**VARIATION OF CONDITIONS 2 ON PLANNING PERMISSION 3/2020/1059 AND 3/2020/1060.  
STANLEY HOUSE, PRESTON NEW ROAD, MELLOR, BB2 7NP**

Atticus Planning is retained by Monte Blackburn Ltd to submit an application under Section 73 of the Town and Country Planning Act 1990 and Section 19 of the Listed Buildings and Conservation Areas Act 1990 to vary the wording of Conditions 2 on planning permission 3/2020/1059 and Condition 2 on Listed Building Consent ref. 3/2020/1060.

**The following plans which were included within Condition 2 attached to application ref. 3/2020/1059 and LBC ref. 3/2020/1060 are sought to be replaced:**

sheet: BEDROOMS - proposed elevations 2 of 2

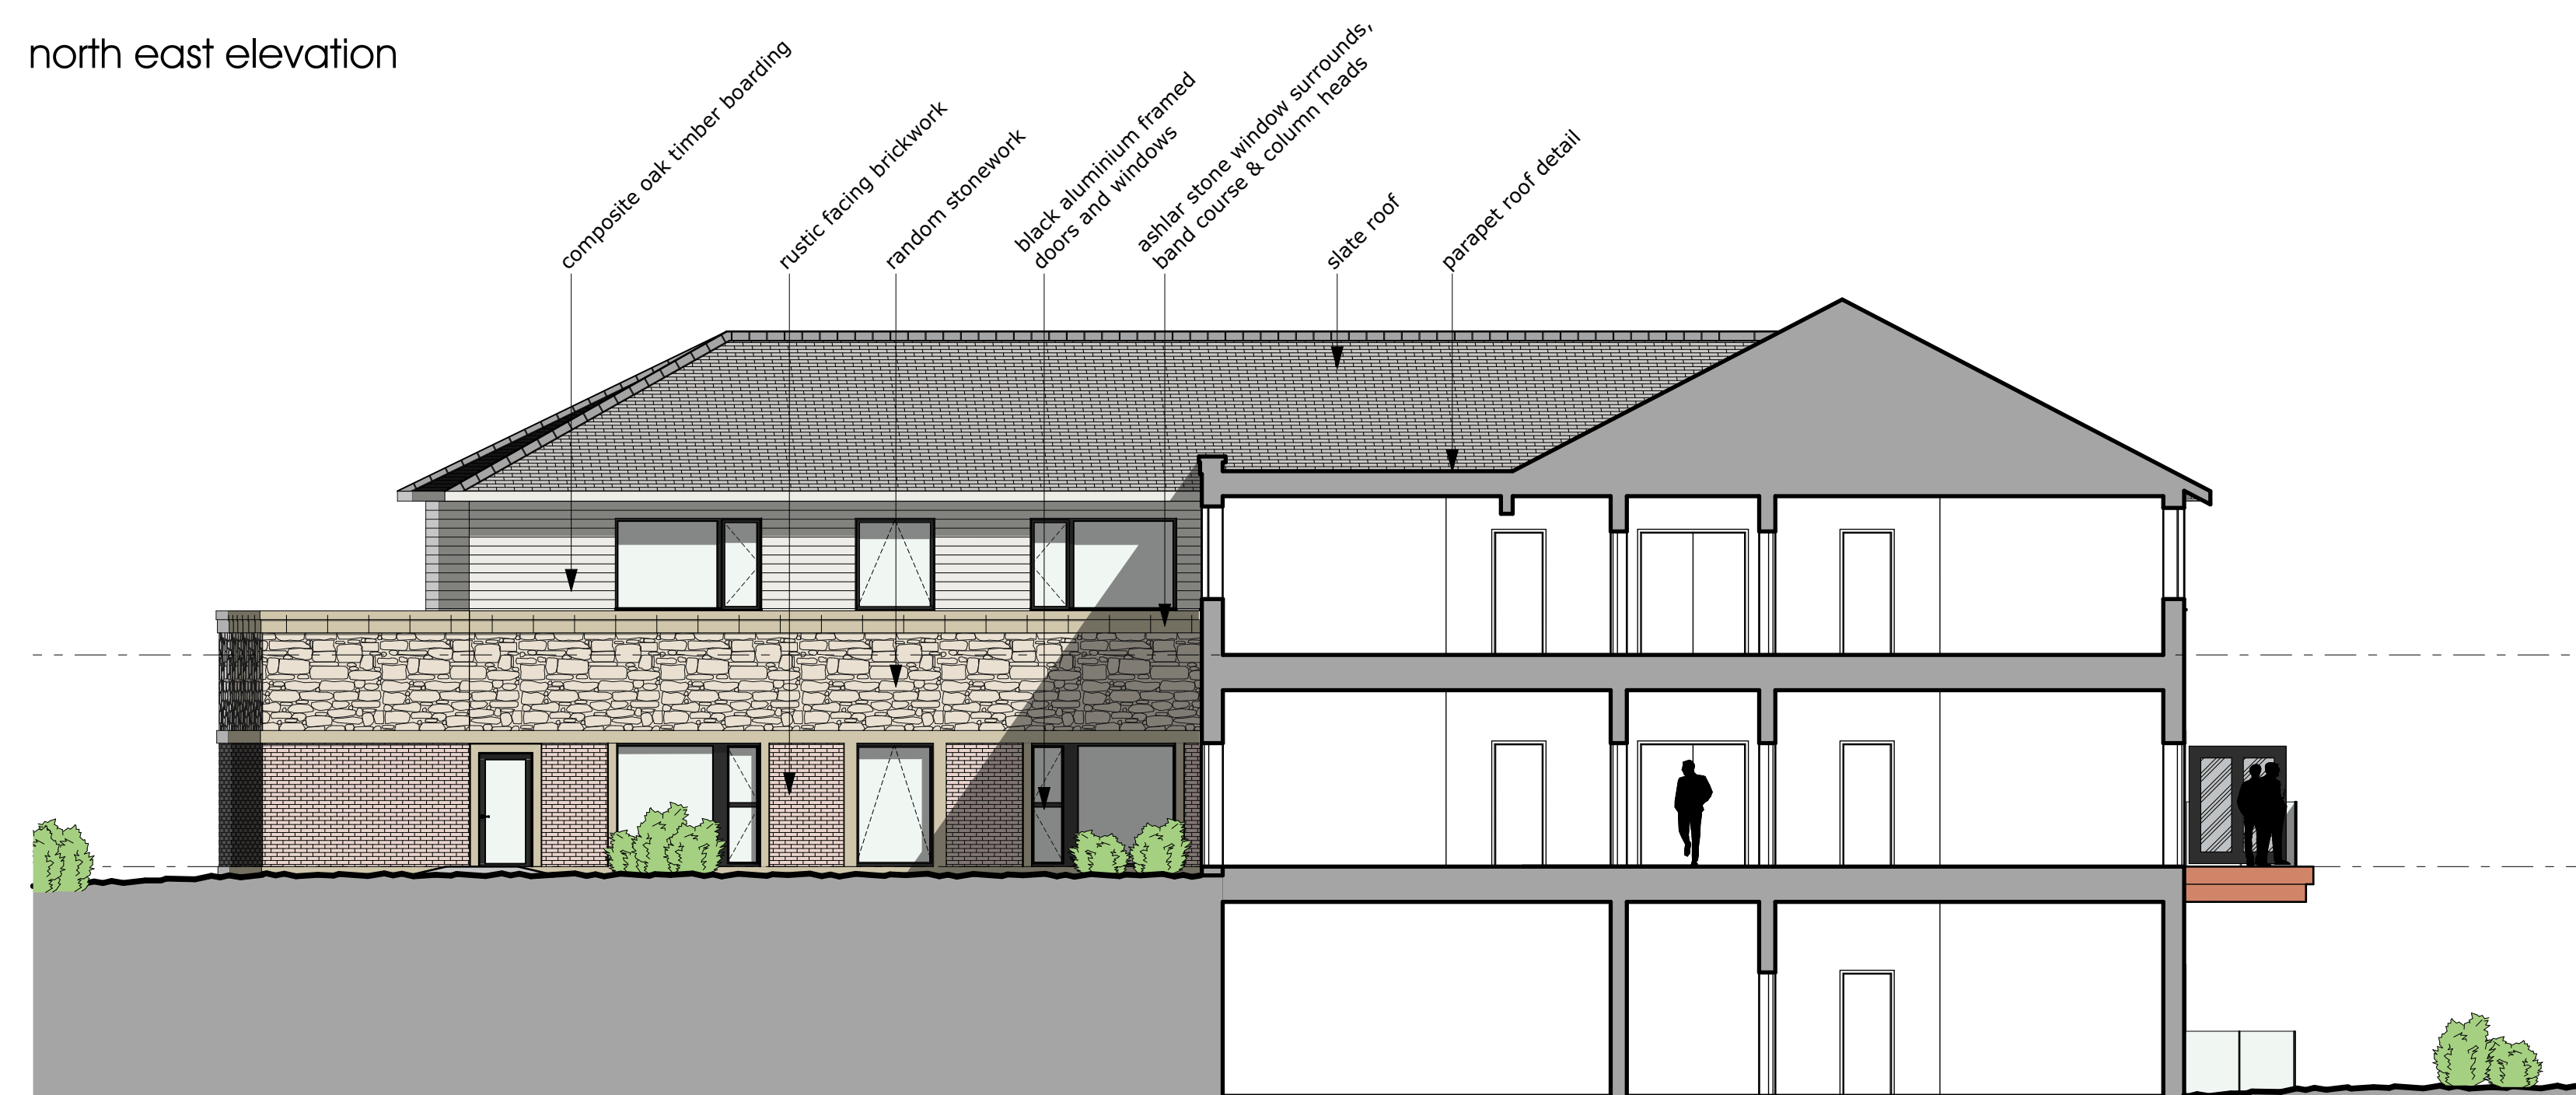
- Removal of small section of sedum roof and bronze / copper cladding.
- **North western elevation –**
  - Increase in first floor window provision from five to ten;

- Increase in window and door openings from five to nine;
  - Removal of small section of sedum roof and bronze / copper cladding;
  - Replacement of bronze / copper cladding with timber cladding.

- **North eastern elevation –**
  - Replacement of bronze / copper cladding with timber cladding.
- **South Western elevation –**
  - Repositioning of location of window and door openings to first and ground floor;

- Removal of small section of sedum roof and bronze / copper cladding.
